RE: **1st Nations Community Healthsource Bldg C Addition**
5608 Zuni SE
Revised Grading and Drainage Plan
Engineers Stamp Date: 2/21/19
Drainage File: L18D047A

Based on the submittal received on 2/25/19, the Grading and Drainage Plan cannot be approved until the following are corrected:

C-002

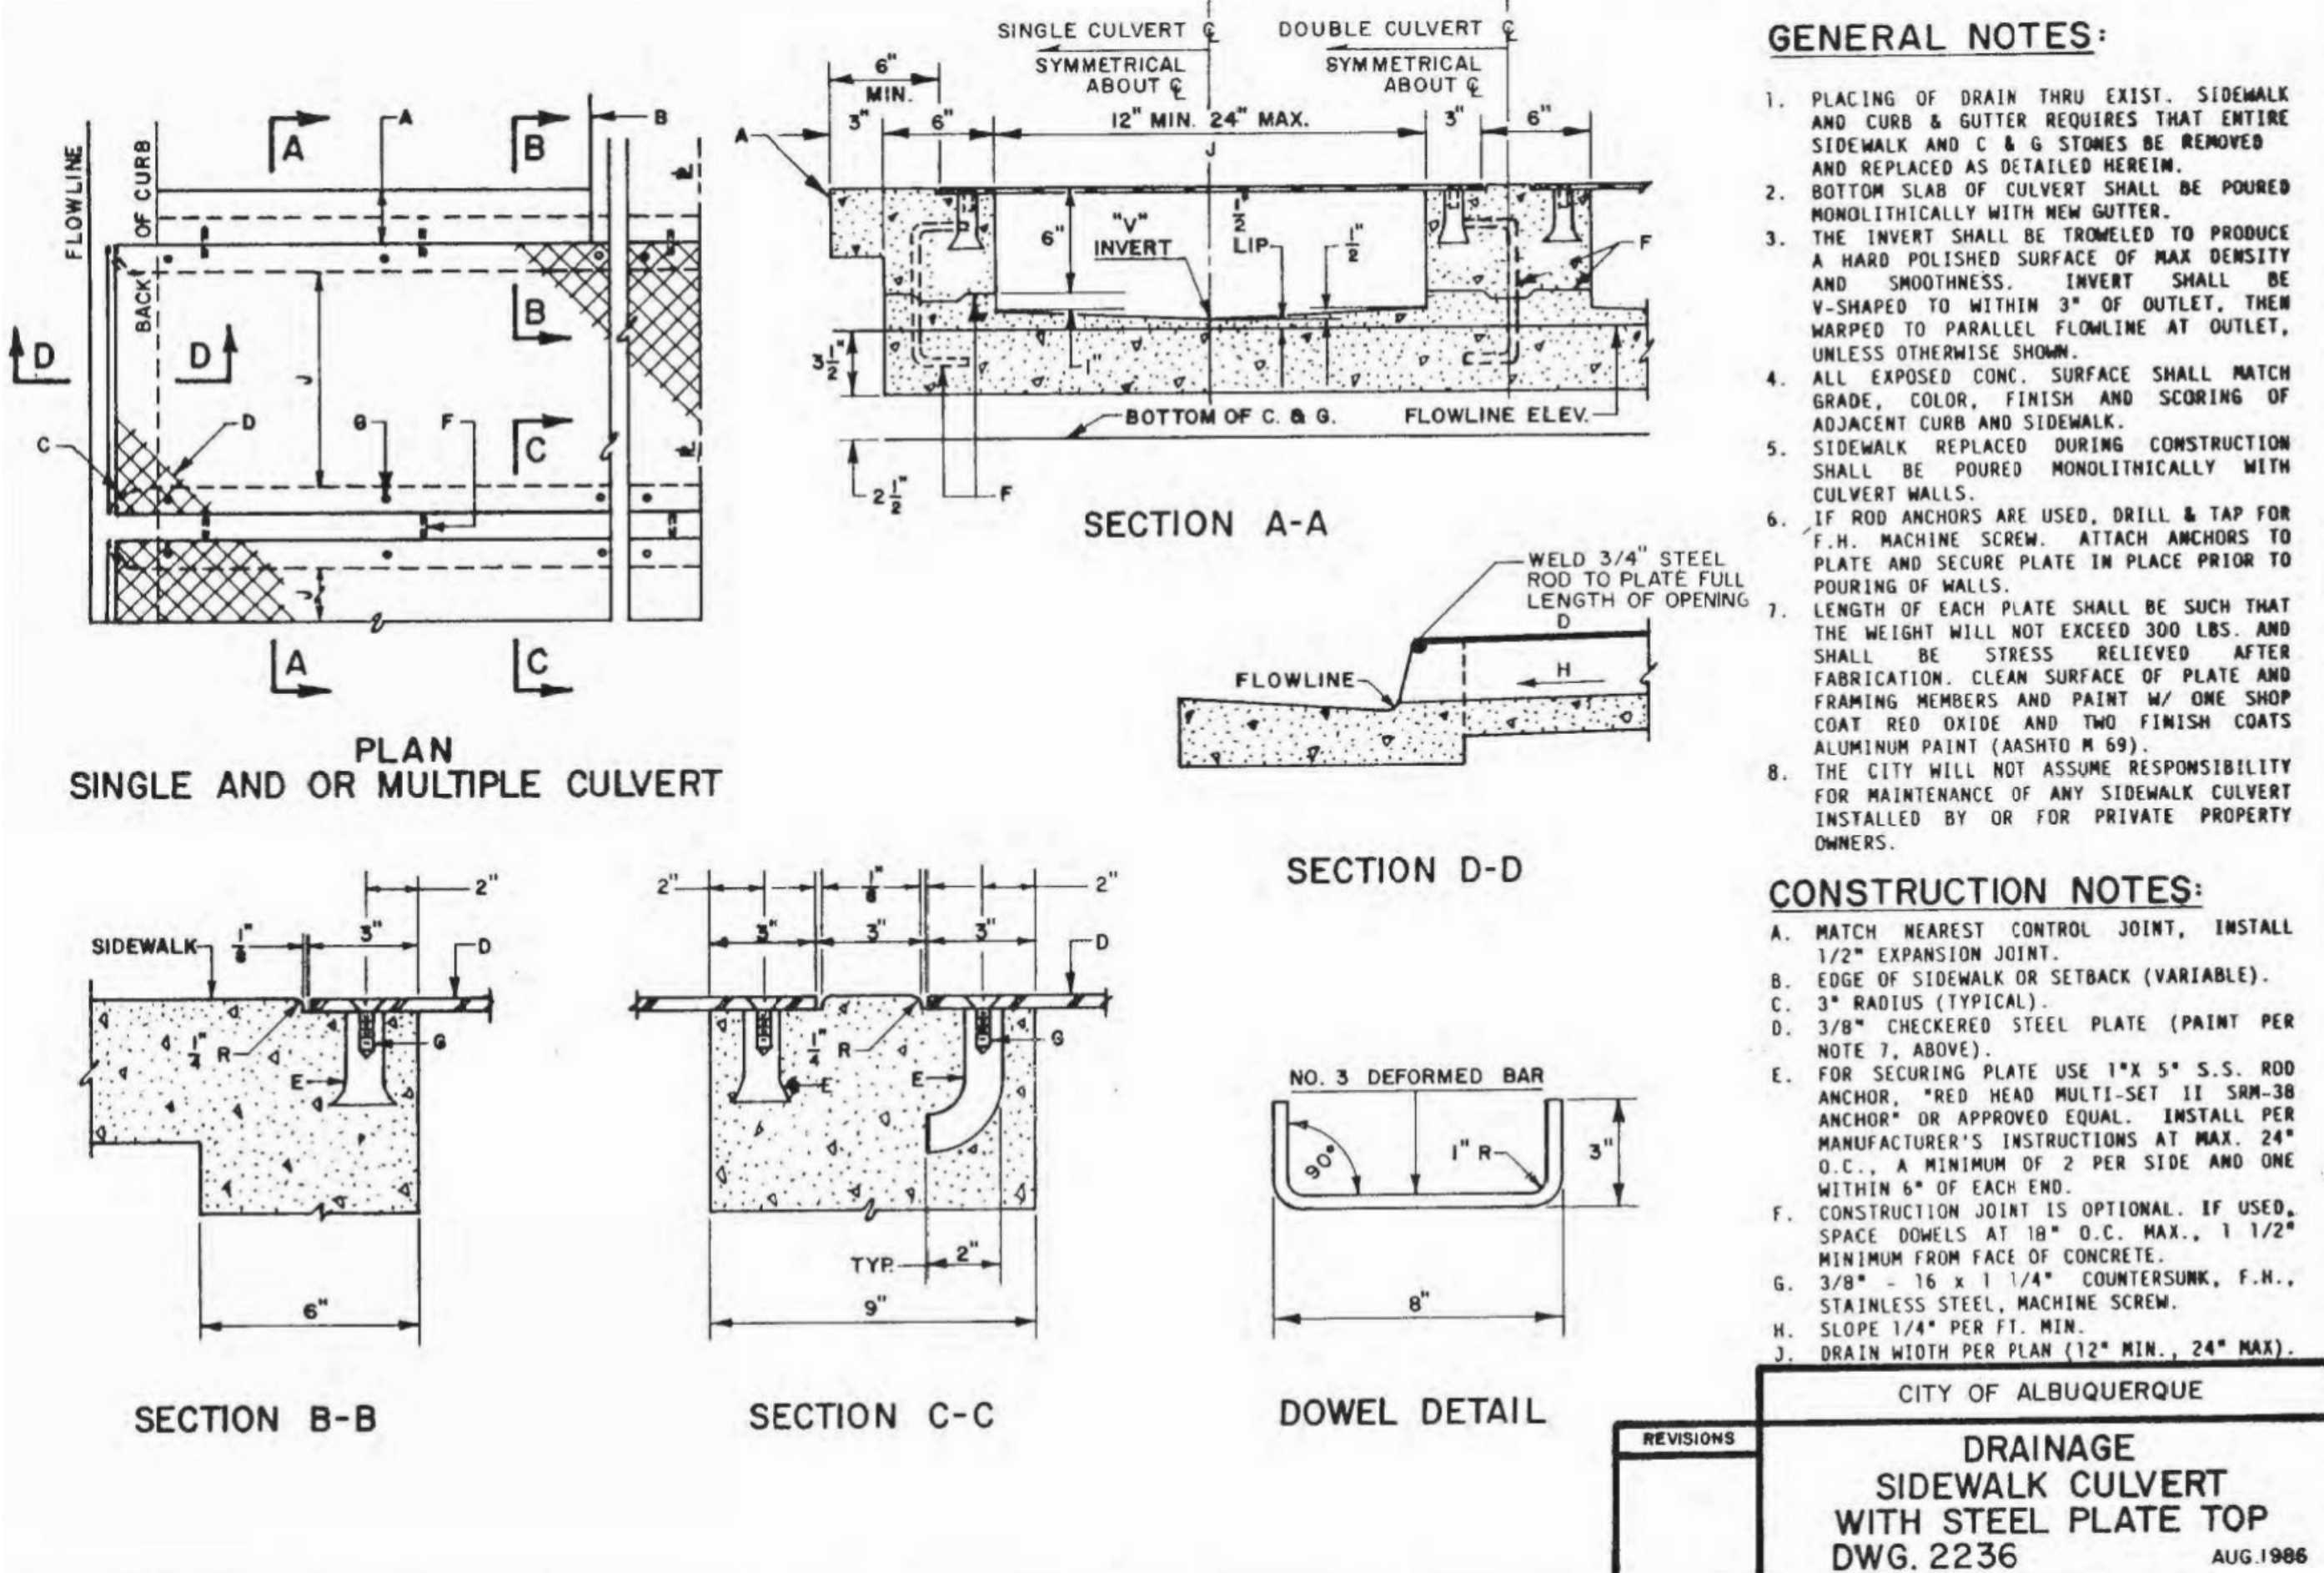
1. The plan needs to clearly state: that the applicant could provide on-site management of the storm water quality volume (SWQV), that the applicant does not wish to provide on-site management, and is requesting to pay a fee-in-lieu of onsite management instead. This site could easily provide onsite retention by relocating utilities to accommodate a pond, by locating the pond under the parking lot (underground storage) or grading the parking lot to drain to another location where utility conflicts do not exist.
2. Payment of the Fee in Lieu (Amount = $207\text{CF} \times \$8/\text{CF} = \1656 , per sheet C-002) of onsite management of the SWQV must be made. Include a copy of the paid receipt when resubmitting.
3. An SO-19 Permit will be required; please include the [standard SO-19](#) notes on the grading plan.
